From: alan.story@hertfordshire.gov.uk
To: [Planning](#)
Subject: Planning application 6/2018/1956/FULL - Stanborough School
Date: 22 October 2018 10:04:45

HCC ref: WH/228/2018 (Amended)

Stanborough School
Lemsford Lane
Welwyn Garden City
AL8 6YR

Erection of new teaching block , replacement tarmac play areas and additional parking provision

work stage	DEVELOPED DESIGN
drawing status	PLANNING
job no. + work stage + building + drawing no.	2155 03 0003
revision	-

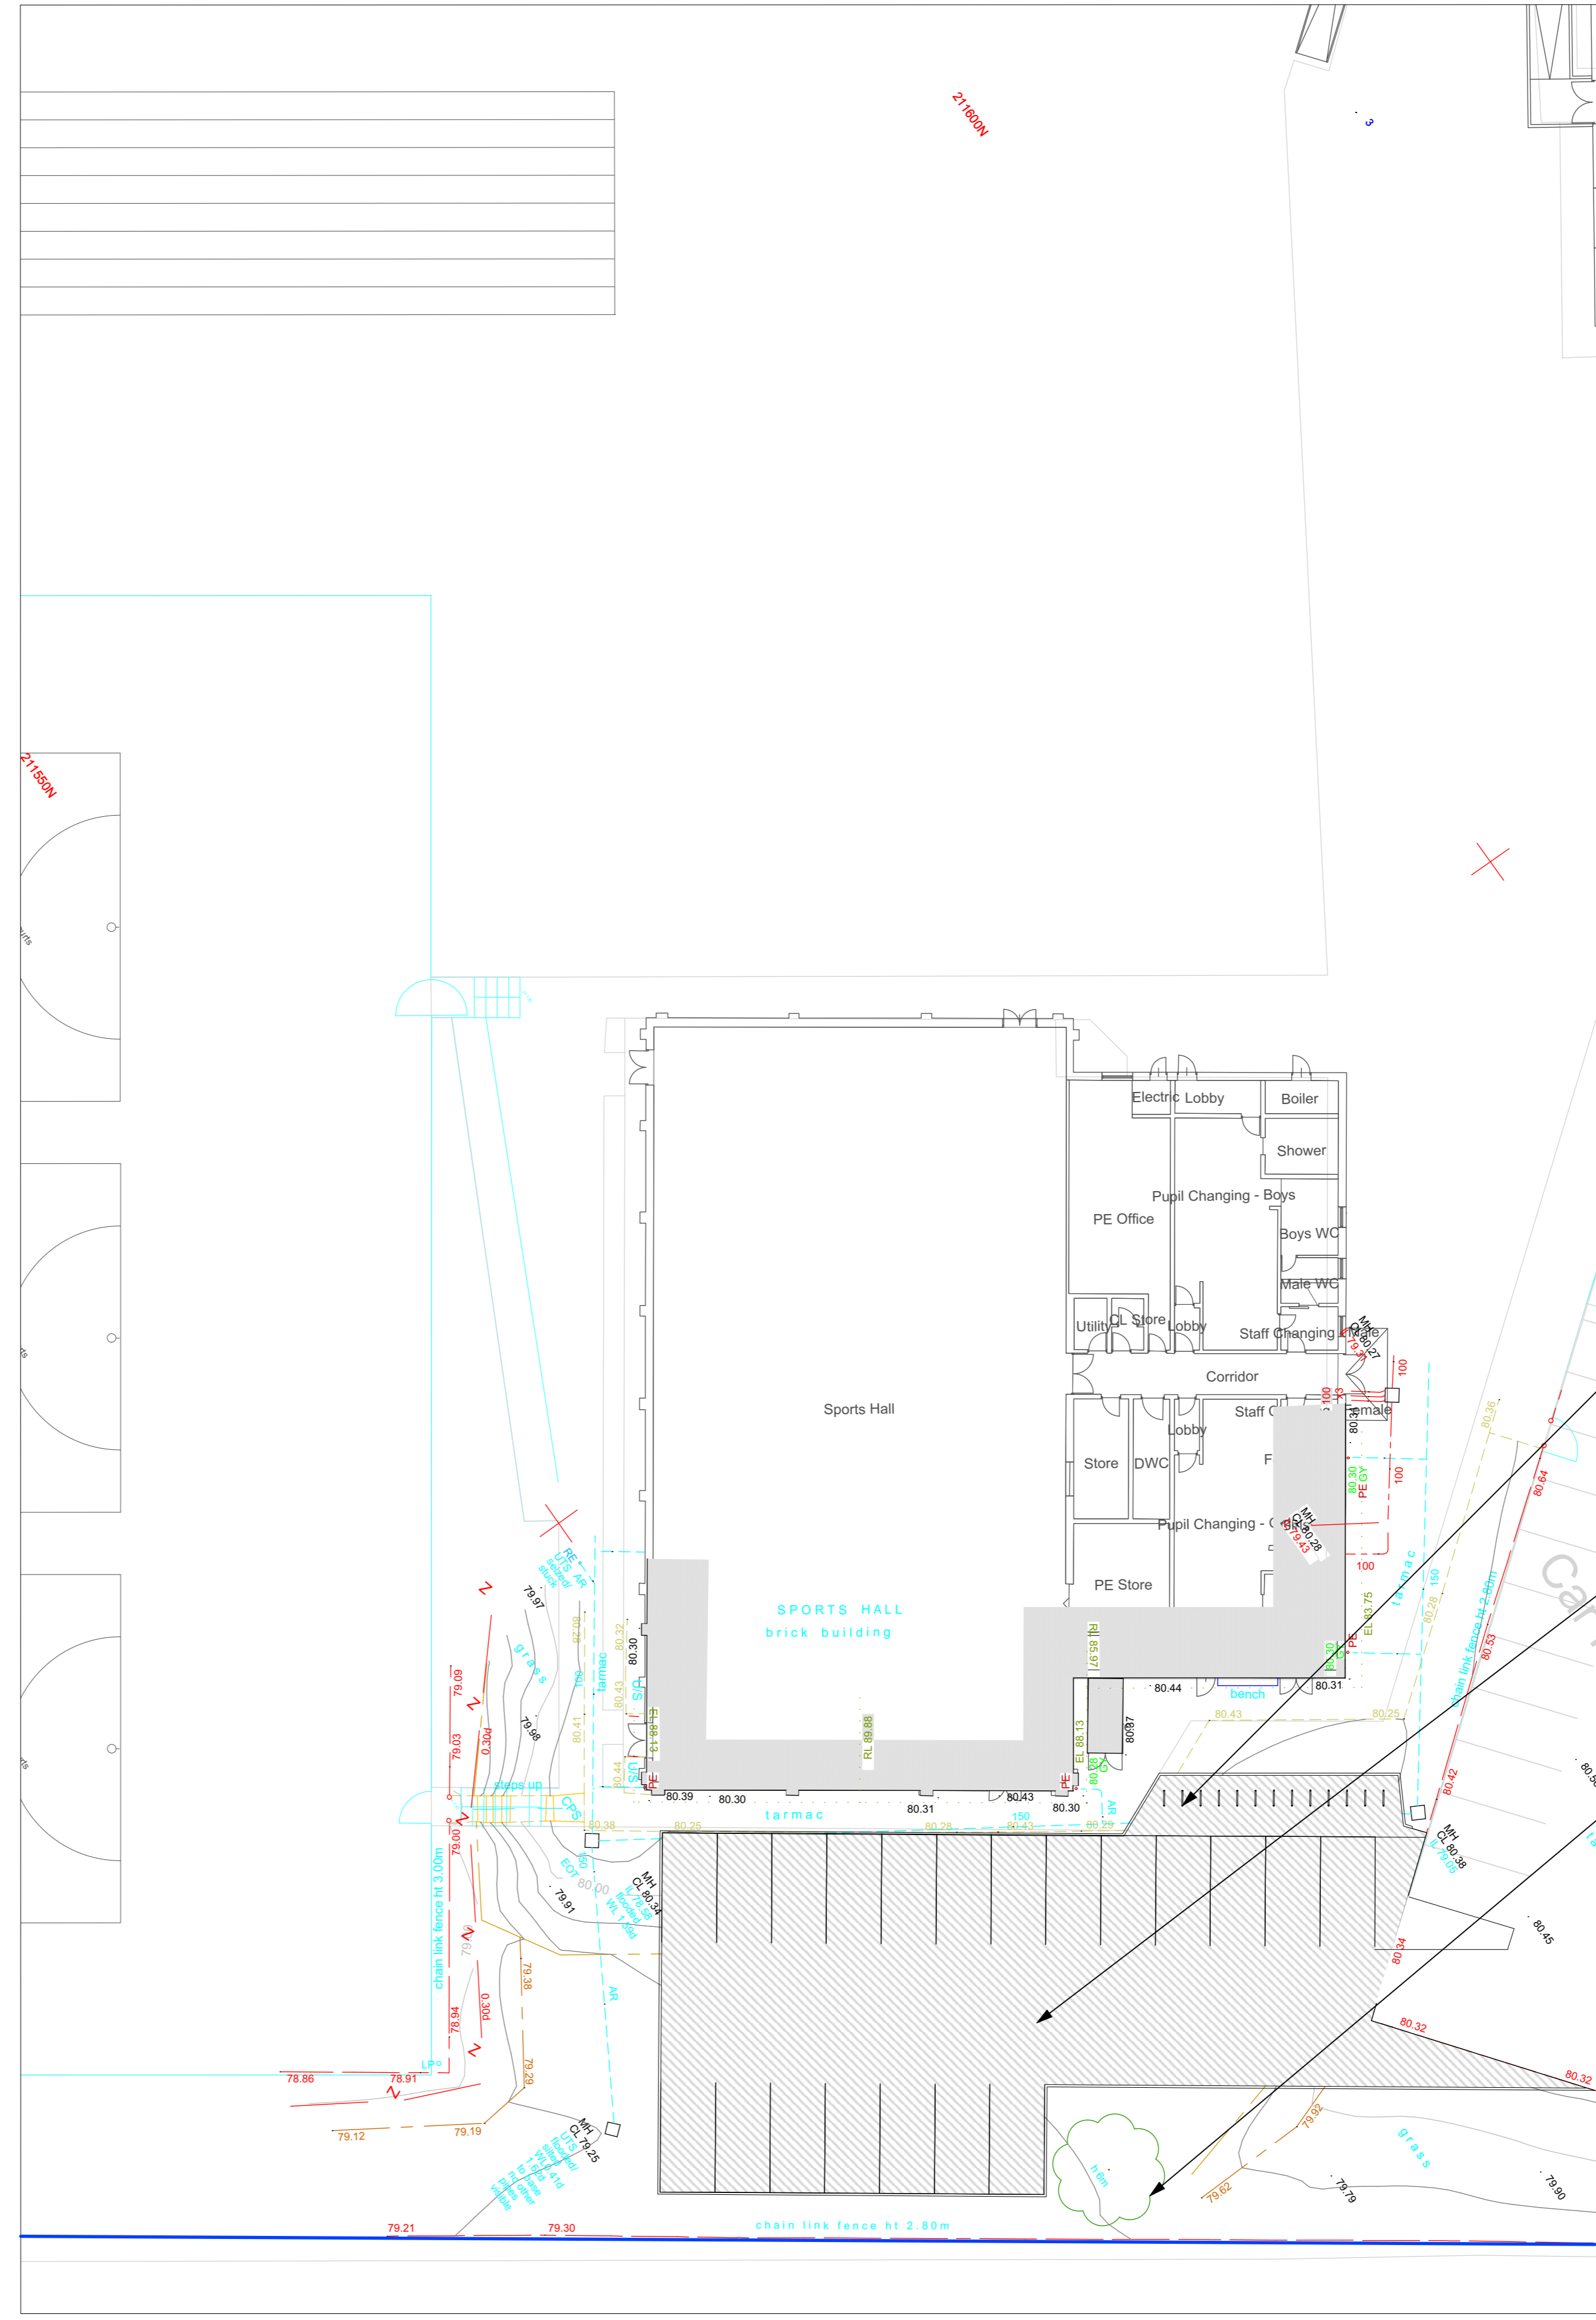
Review of drawing 2155-03-0100, would suggest that there are 138 spaces outside the area of new parking proposed. It is necessary to observe that 52 of the parking spaces (existing) are provided through the use of area defined as netball courts. The HA have no information on whether the LPA has approved the shared use of such spaces as parking.

The new car parking is located by way of entry through the netball court / car park overflow – the LPA shall wish to consider whether the netball pitches are permitted to form part of the parking supply to the school, and observed that the provision of the additional car parking shall further prejudice the likelihood of their availability as sports facilities in the future, noting the potential vehicle access requirement.

The proposed car parking is set out appropriately in terms of car parking layout, however shall require the removal of some of any perimeter fencing to the netball court to enable

The TA identifies that to provide for the needs of cyclists there will be a requirement against local standards for a further 26 cycle parking spaces to be provided. The proposals provide this (drawing 2155 03 0100) by way of Sheffield stands within the new car parking area.

The Highway Authority's LTP4 Policy 1 establishes a user hierarchy and promotes non-car modes of travel, the provision of cycle parking is a welcomed inclusion however in the position proposed shall be unattractive to cyclists requiring them to ride through car parking areas and located in an area that is unlikely to receive significant natural surveillance making the security of cycles stored in this location at risk. No detail is provided whether cycle facilities would be covered or secured. Cycle stores would benefit from alternate location to make them more prominent, thereby promoting their use as well as increasing natural surveillance and improving security. The LPA may consider requiring alternative solutions to cycle parking.

4) Prior to the first occupation of the development a revised scheme for the parking of cycles has been submitted to and approved in writing by the Local Planning Authority. The approved scheme shall be fully implemented before the development is first occupied or brought into use and thereafter retained for this purpose. Reason: To ensure the provision of adequate cycle parking that meets the needs of the school and in the interests of encouraging the use of sustainable modes of transport.
